**Consultation Response from KC,
Trees**

2025/92180 adj, 16a, Town Gate, Scholes, Cleckheaton, BD19 6ET

Demolition of existing garage and erection of single storey dwelling with front and rear dormers

Date Responded: 12/11/2025

PROJECT TITLE Proposed New Build to Replace Previous Garage	CLIENT Hillas 16A Salisbury Road, Scholes, BD19 6ET
DRAWING STAGE Planning	SCALE As Drwg @ A1
SHEET TITLE Proposed Plans & Elevations	PROJECT NUMBER BOB-2527
	STAGE PLN
	REV A
	SHT 003

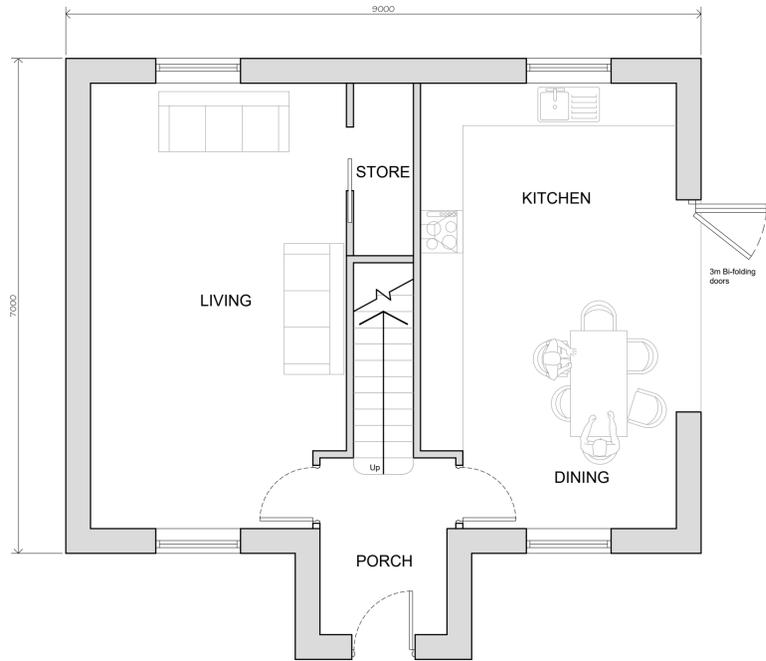
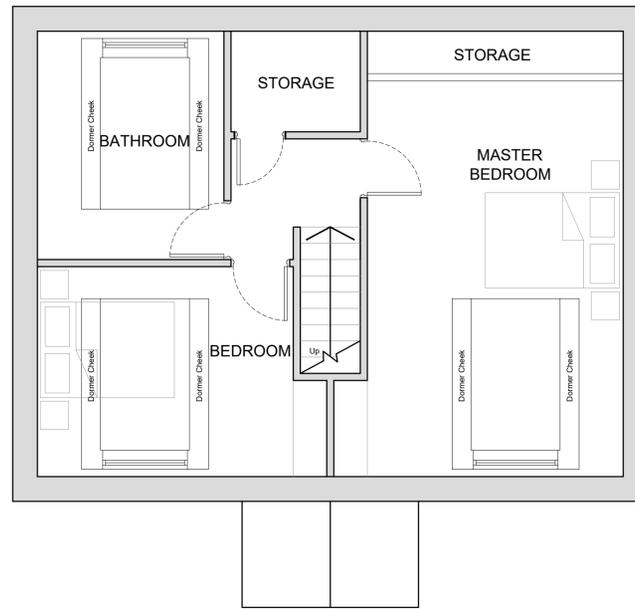
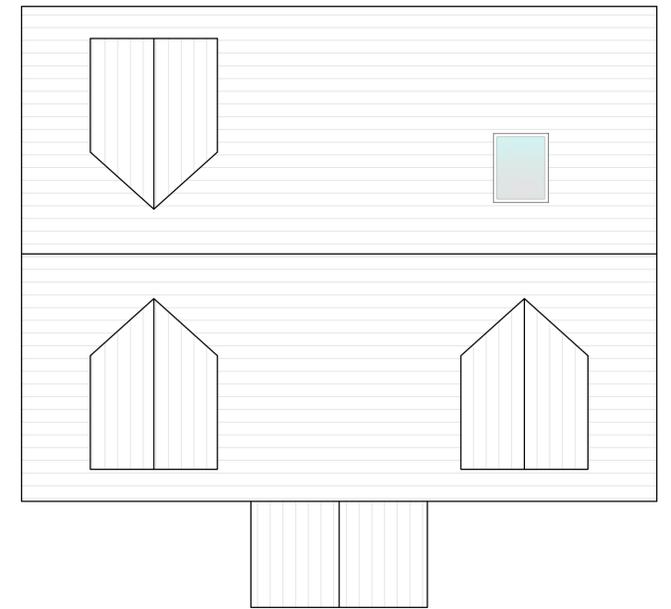
The proposals show that a significant portion of the RPA would be encroached by the development, and it would also encroach the canopy of the protected tree. The degree of incursion is unacceptable as it goes against BS5837 recommendations and would jeopardise the health of the protected tree.

Appendix 6: Arboricultural Implications Plan

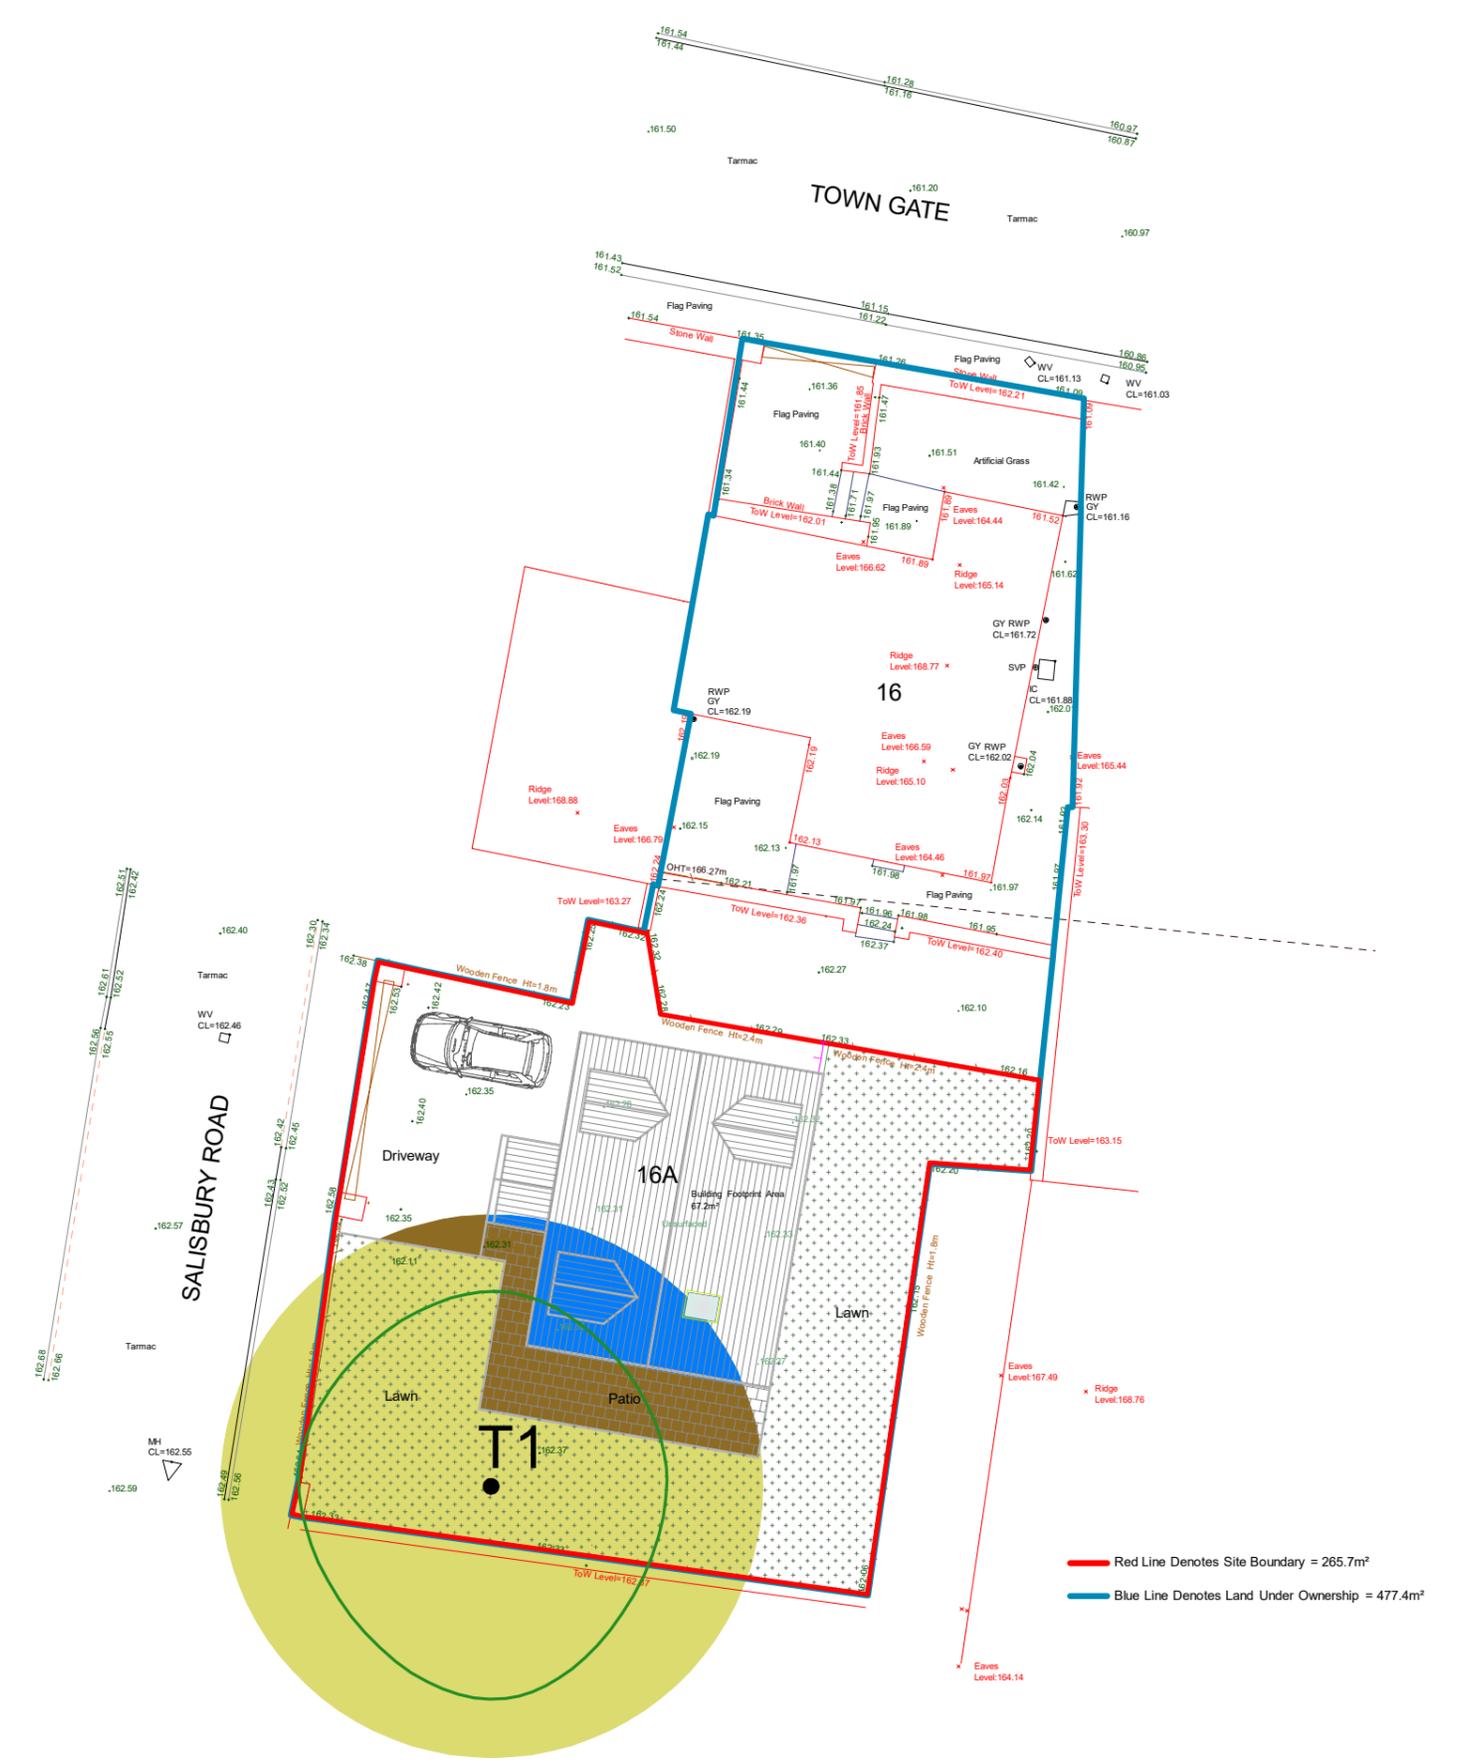
Furthermore, any proposals must ensure that future pressure for removal is avoided. The relationship of buildings to large trees can cause apprehension to occupiers or users of nearby buildings or spaces, resulting in pressure for the removal of the trees. Buildings and other structures should be sited allowing adequate space for a tree's natural development, with due consideration given to its predicted height and canopy spread.

There is an objection from an arboricultural perspective. The proposal conflicts with adopted Kirklees local plan policy 33 and 24 (i).
